CITY OF ALBUQUERQUE

PLANNING DEPARTMENT – Development Review Services

RE: **Anderson Height Unit 4 (File: N08D006F)**
Drainage Report, Engineer's Stamp Date 2-12-2015
Grading & Drainage Plan Engineer's Stamp Date 5-1-2015

TITLE: **ANDERSON HEIGHTS - UNIT 4
GRADING & DRAINAGE PLAN**

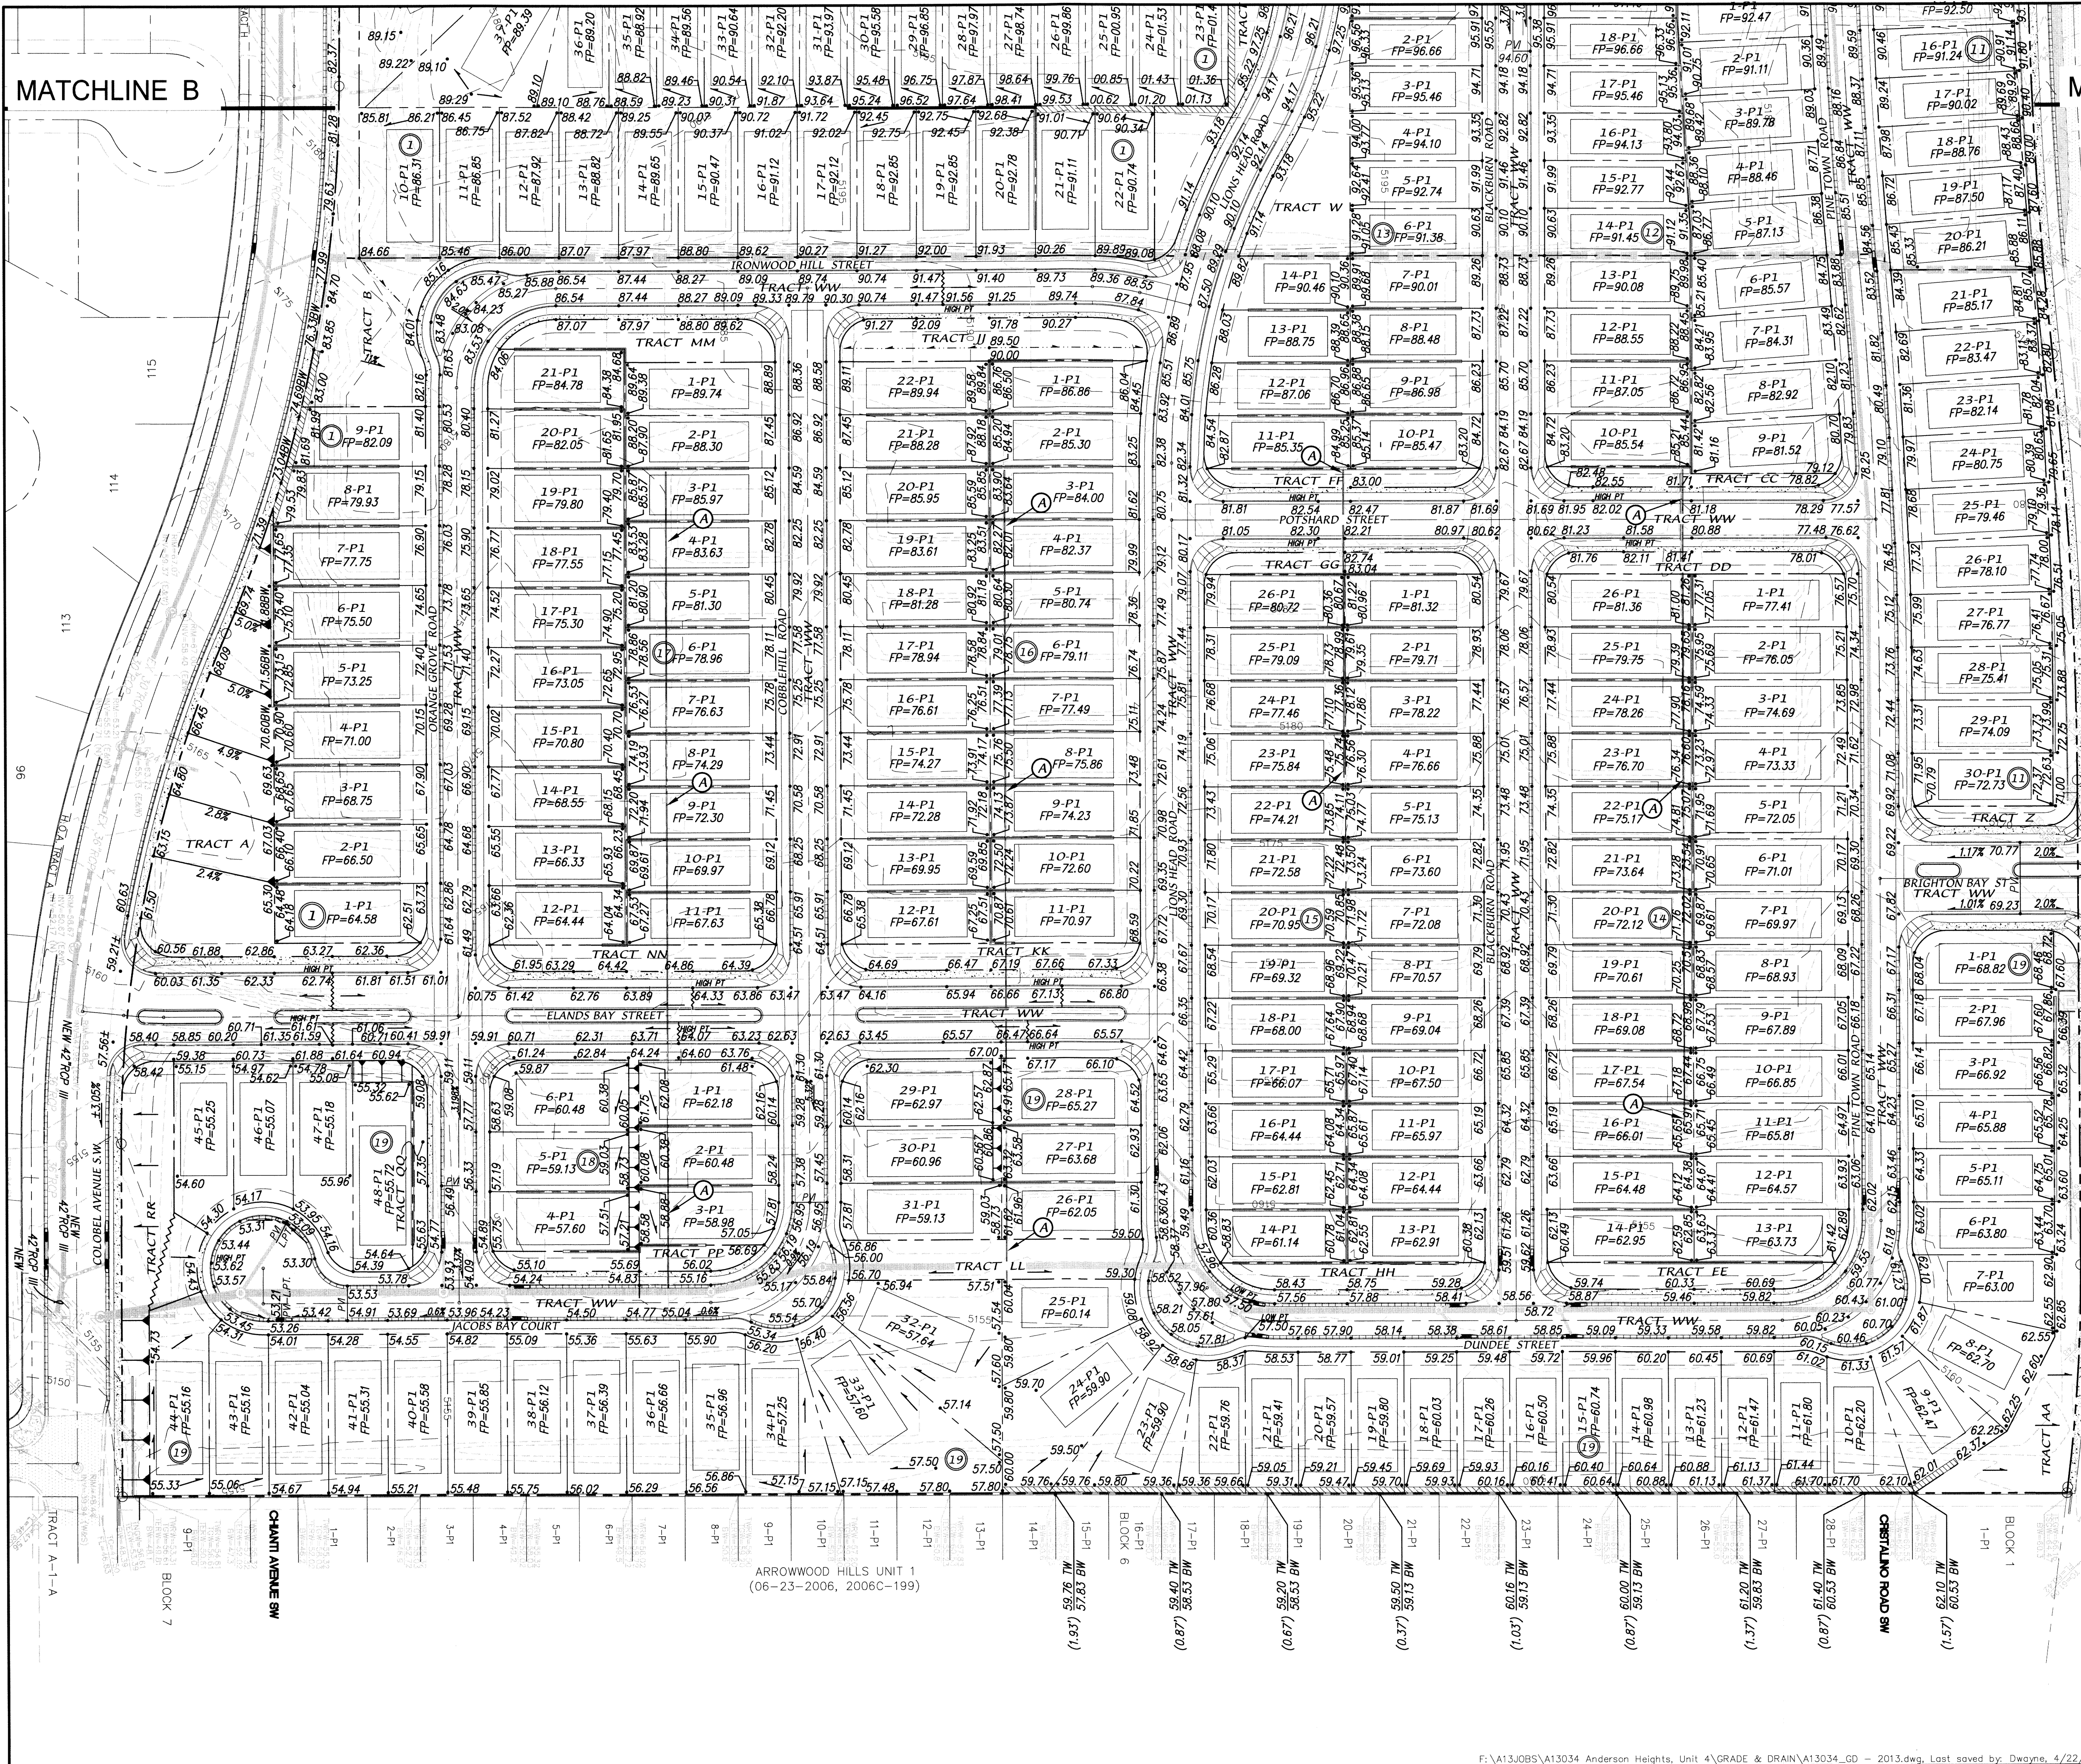
3. Retaining wall along the eastern boundary:
 - Show the existing retaining wall built with the Arrowwood Subdivision. Call out as existing, and to protect in place.

- Show/note removal of the existing retaining wall that was built later (Unit 9 G&D, stamp date 9-10-07). The entire wall is to be removed as it was built too close to the previously existing wall and the existing wall is not designed for the additional pressures.

- A new retaining wall is to be built some distance away from the existing wall (Arrowwood Subdivision). Show on the plan at the correctly scaled distance and provide section cuts .

- There is sufficient reason to believe that the new walls need to have footings extend as far down as the existing walls built with Arrowwood subdivision. Please show this on the section cuts.

- Your legend defines TGW as something other than Top of Garden Wall, please redefine.
 - In lieu of the above comments, a structural engineer may be contracted to determine another solution.

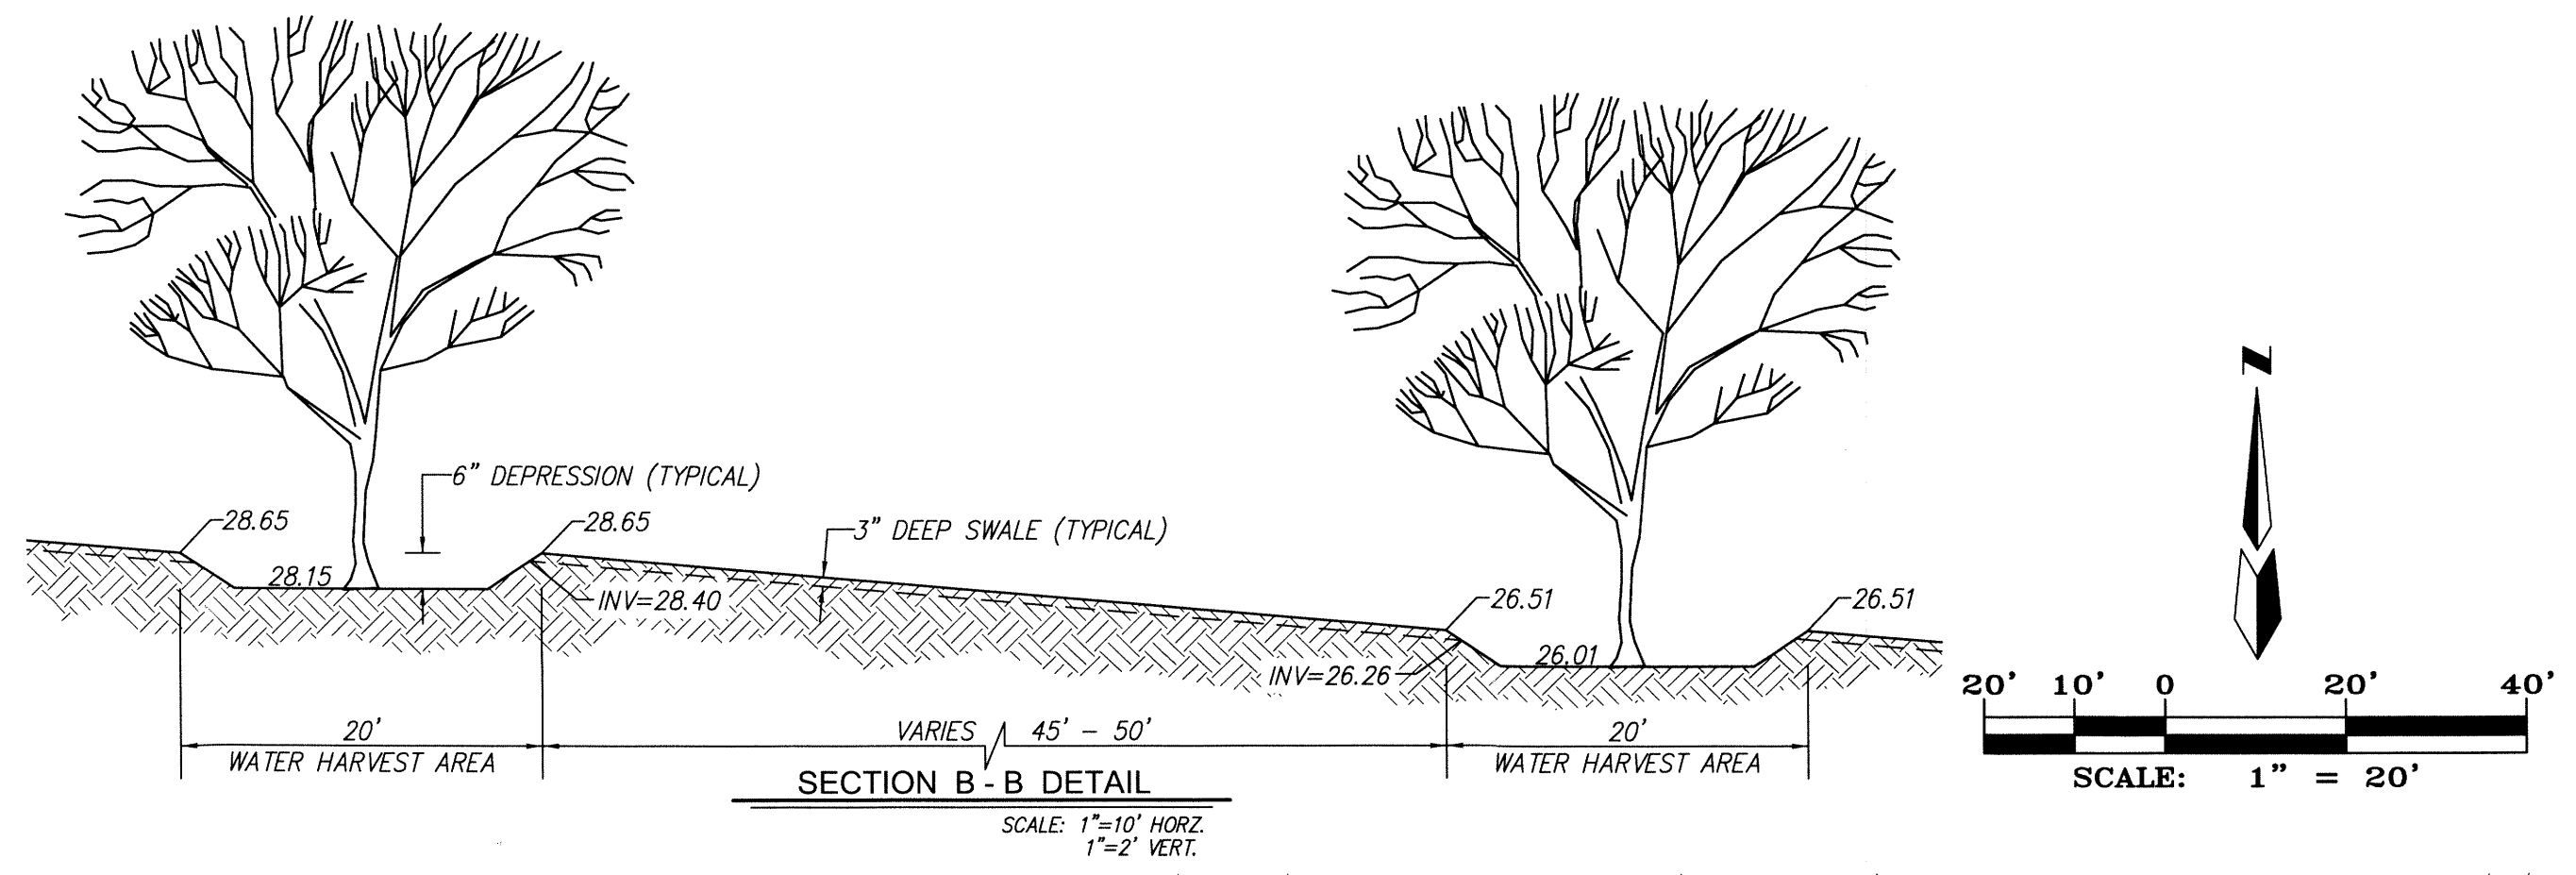
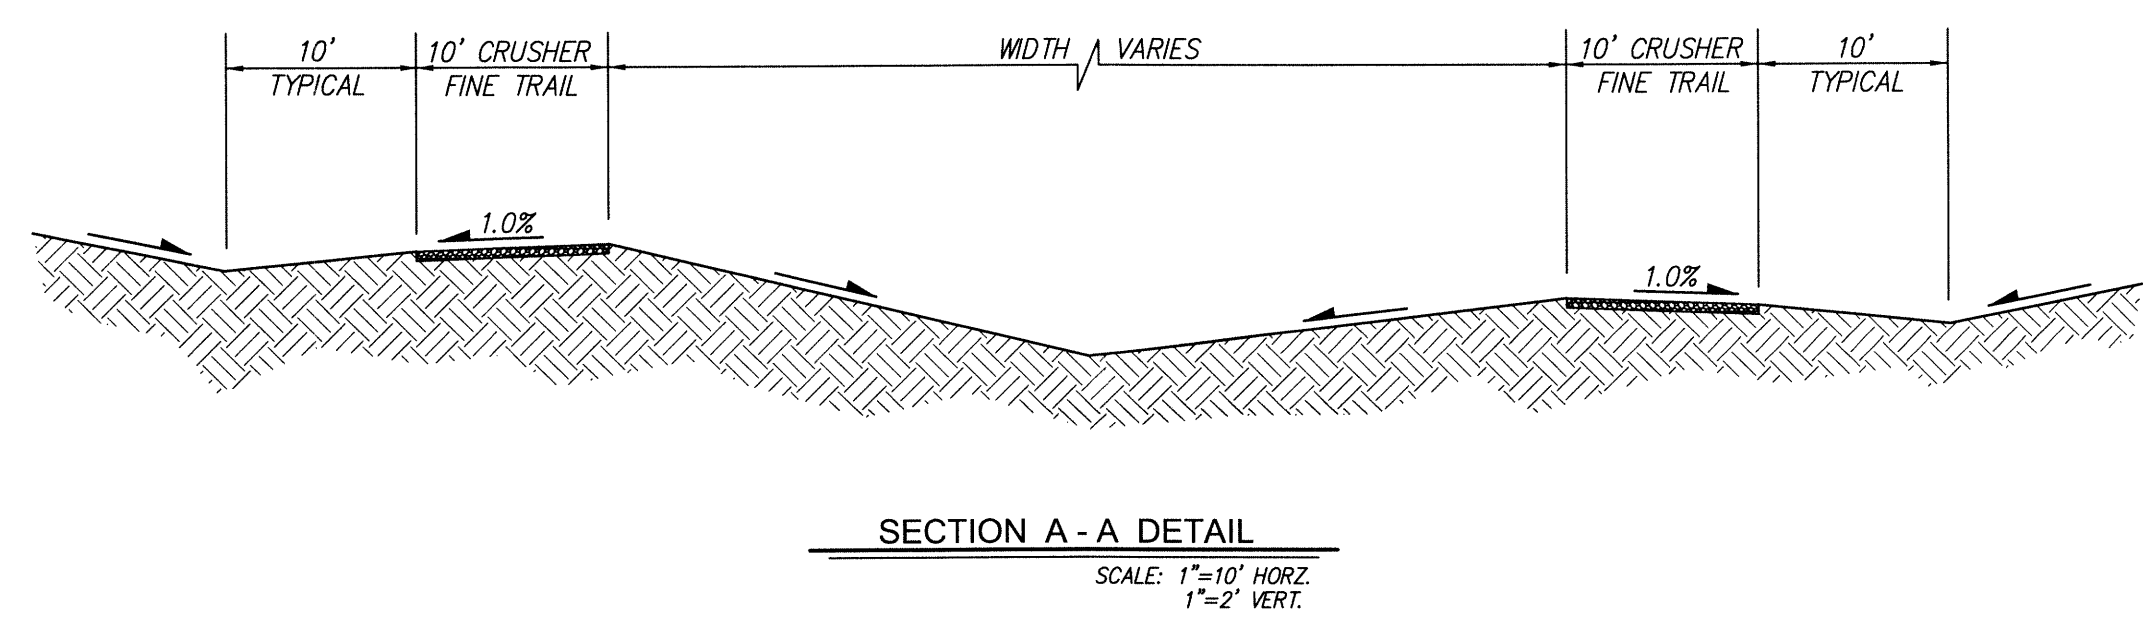
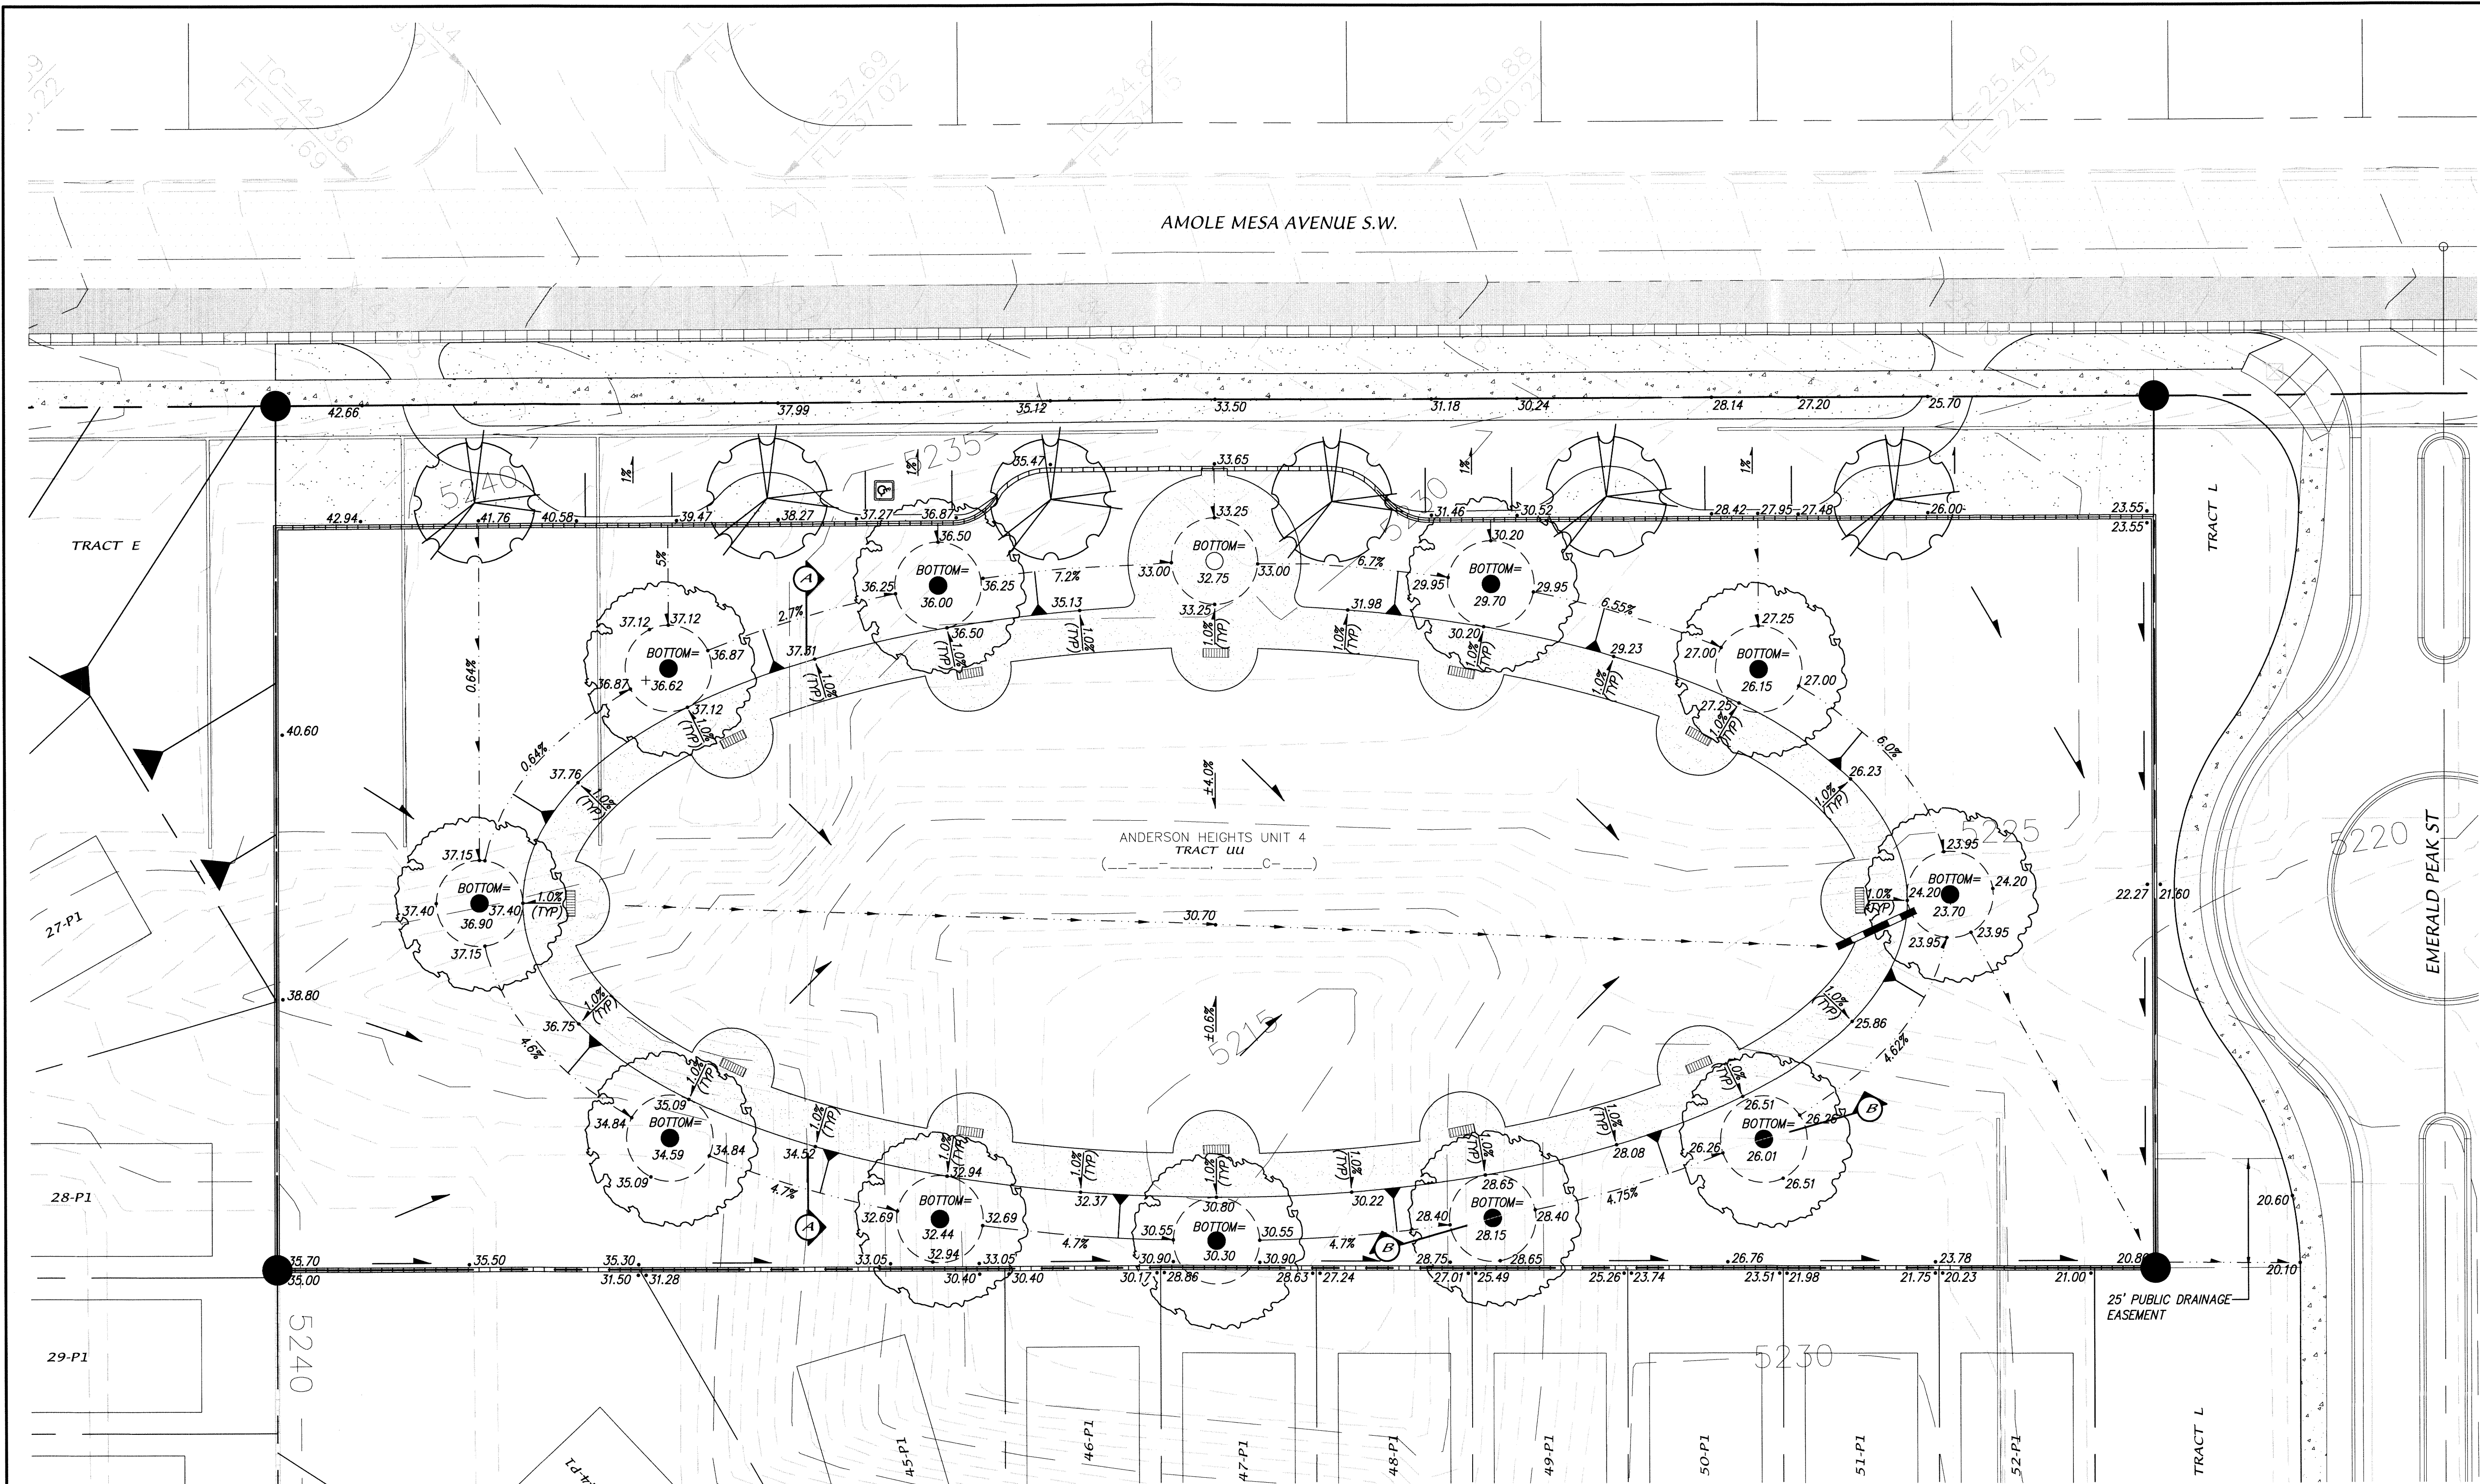
1. Typical retaining wall details on Sheet 2 of 4 show a 9' wall height (garden wall ht. plus retained ht). Per zoning, the maximum allowed wall height is 8 ft. Adjust the retained height of the lower walls such that the highest wall is 8' max.
